THE COLONG FOUNDATION FOR WILDERNESS LTD.

Monday 22nd August, 2016

Springvale Mine Extension Project (SSD 5594) – Modification 1 proposal

## APPENDIX 2: DEVELOPMENT LAYOUT PLAN

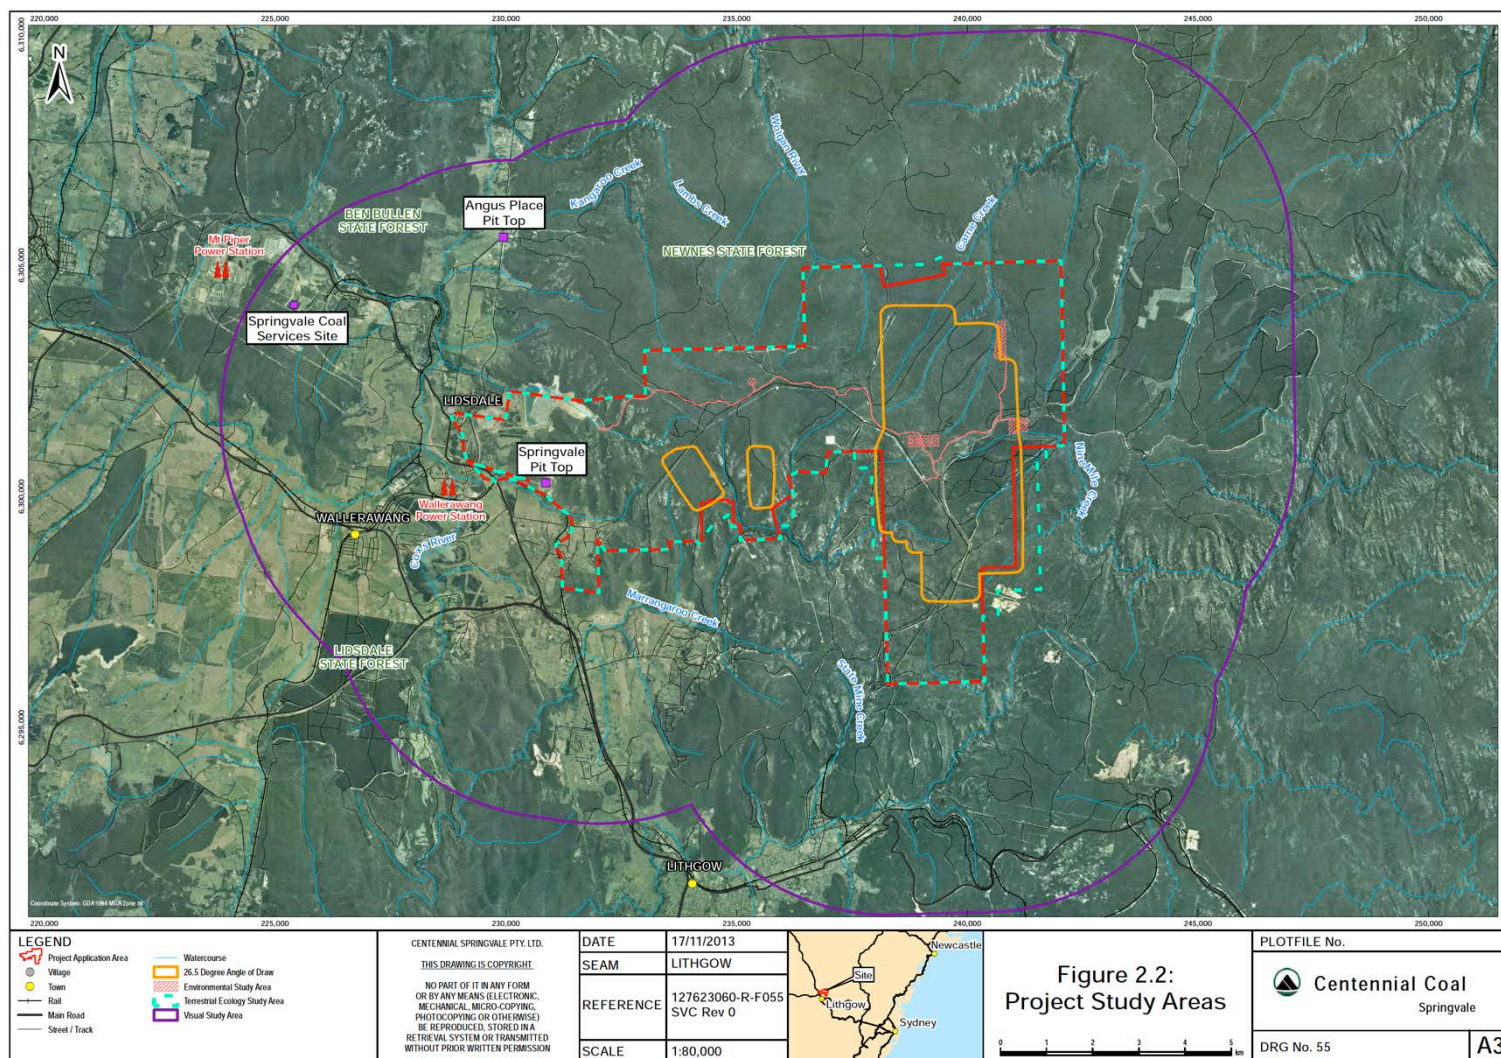
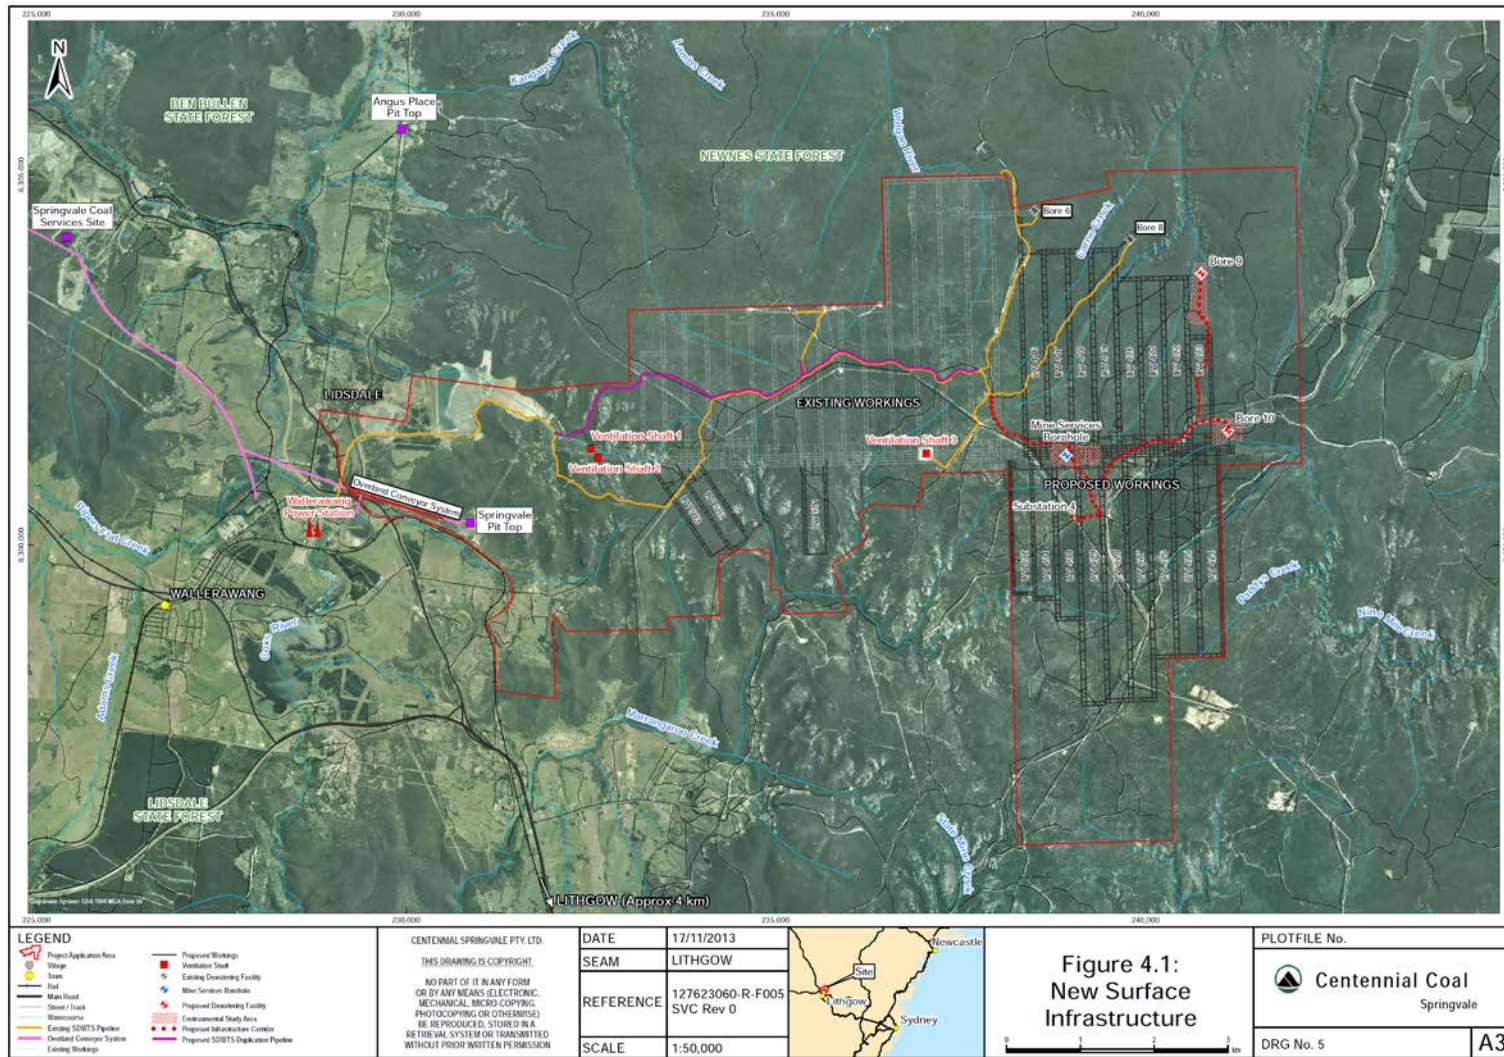
Shorten the northern and southern ends of LW420 to prevent swamp undermining to ensure no more than negligible impact to Gang Gang Swamp South West, and prevent flow impacts to downstream waterfall structure and avoid more than negligible impact to Gang Gang East Swamp.

Omit LW421 to prevent to prevent swamp undermining and ensure no more than negligible impact to Gang Gang Swamp South West and Gang Gang East Swamp, and prevent flow impacts to downstream waterfall structure.

Shorten the northern end of LW422 to prevent to prevent swamp undermining and ensure no more than negligible impacts to Gang Gang Swamp South West and Gang Gang East Swamp, prevent flow impacts to downstream waterfall structure.

Split LW424 to prevent swamp undermining and ensure no more than negligible impacts to Pine Swamp and shorten the southern part of the split LW to prevent more than negligible impacts to Paddys Swamp.

Split LW425 to prevent swamp undermining and ensure no more than negligible impacts to Pine Swamp.

Split LW426 to prevent swamp undermining and ensure no more than negligible impacts to Upper Pine Swamp and Pine Swamp Hanging.

Split LW428 to prevent swamp undermining and ensure no more than negligible impacts to Marrangaroo Creek Swamp.

Shorten the southern end of LW429 to prevent swamp undermining and ensure no more than negligible impacts to Marangaroo Creek Swamp and Marangaroo Creek Upper Swamp.

Shorten LWs 430-432 to ensure Marangaroo Creek Swamp is not undermined and does not experience greater than negligible impacts.
